Application by Longfield Solar Energy Farm Limited for an Order Granting Development Consent for the Longfield Solar Farm project.

The Examining Authority's Further Written Questions and Requests for Information (ExQ2)

Issued on 18 October 2022

Outline Landscape Masterplan
Sheet A

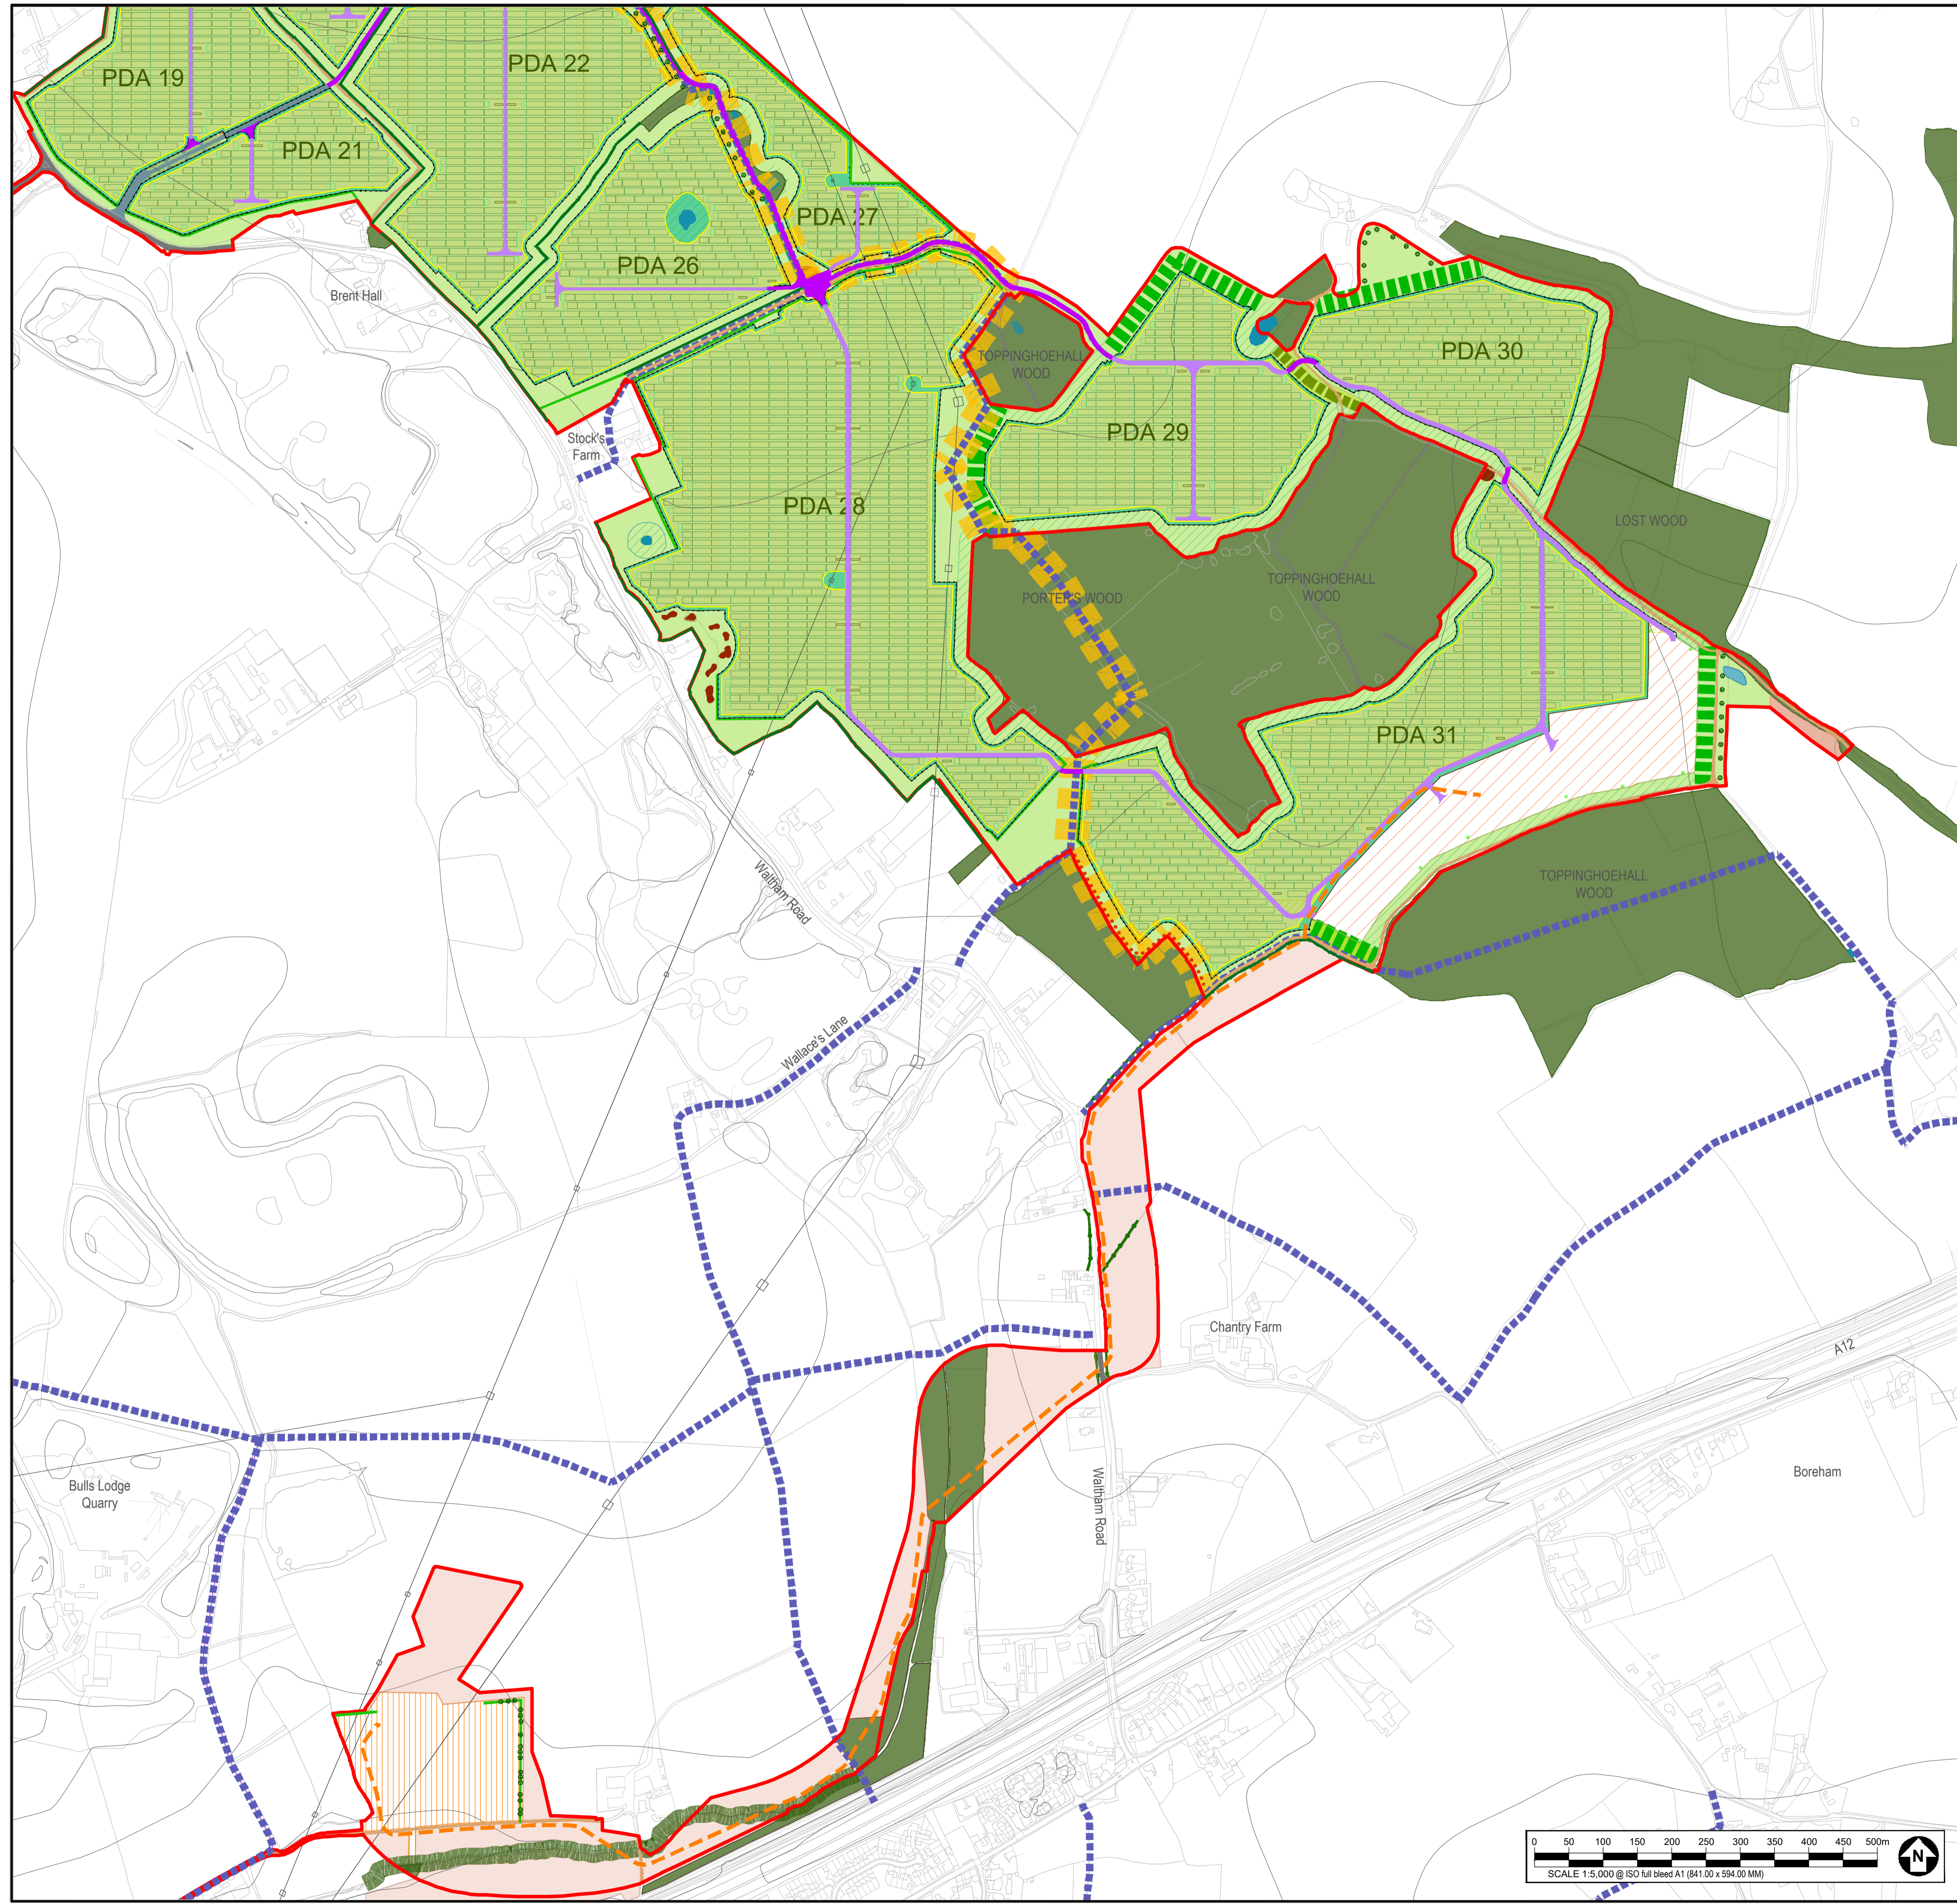
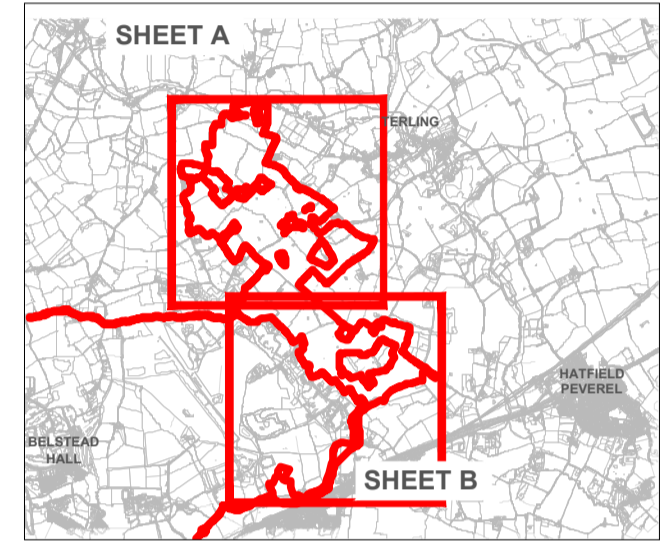
8. Landscape and Visual Effects		
2.8.1	Applicant	<p>Table B-20 (LVIA) of the Applicant's Response to Relevant Representations [REP1A-002], (responding to RR-48 and RR-59), states that an assessment of the proposed lighting on ecology has been undertaken in ES Figure 10-12: Outline Landscape Masterplan [APP-179].</p> <p>Please indicate where on the Outline Landscape Masterplan this assessment can be found.</p>
